Subject: Land Adjoining and West of Bloxham Recreation Ground, South Newington Road,

Planning Ref: 19/01705/OUT

Find below replies to the comments of Richard Bennett (LLFA)

Figure 3.10: Map showing extent of Flood Zones and areas of surface water flooding.

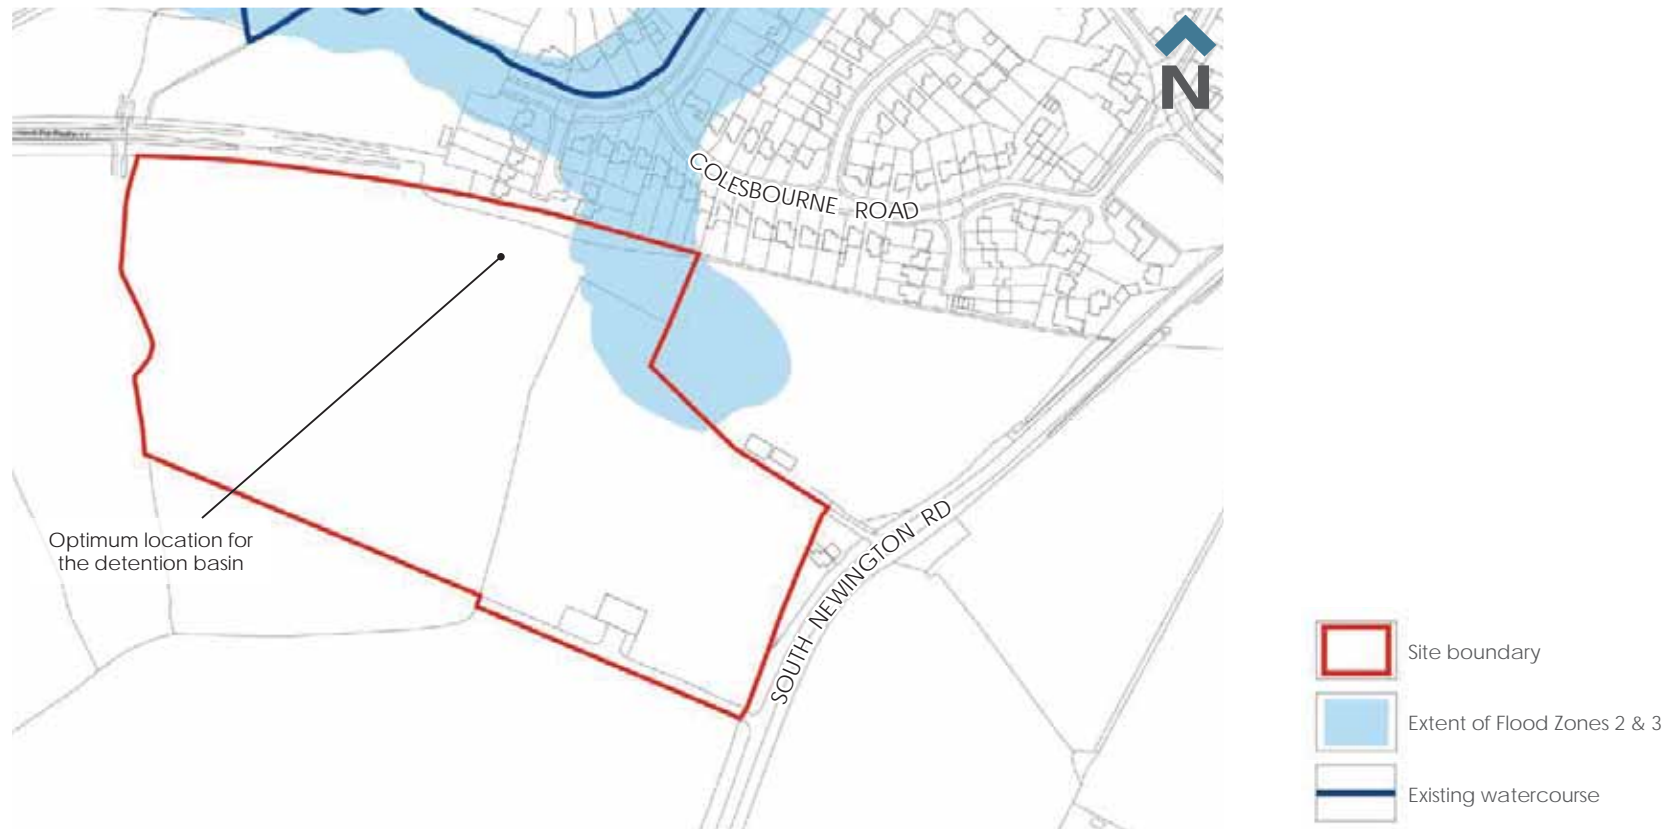
Site is partially in Flood Zone 2 and 3 as noted in FRA. Evidence required from Environment Agency that they are happy to permit development.

FRA notes significant area to the North of the site which is prone to flooding.

Evidence/justification required as to how this will be mitigated, i.e. shallow basins for temporary shallow sacrificial storage.

Discussions are being held with the EA but the attached plan shows that Flood Zones 2 & 3 within the site are restricted to the edge in the north east corner of the site with the development area being in Fluvial Flood Zone 1

There is a potential Surface Water risk shown on the plans in the northwest but there is no development shown within the area. It is also a different catchment from the developed area (photo of the culvert to the north of the site that would collect the flow from the northern area).
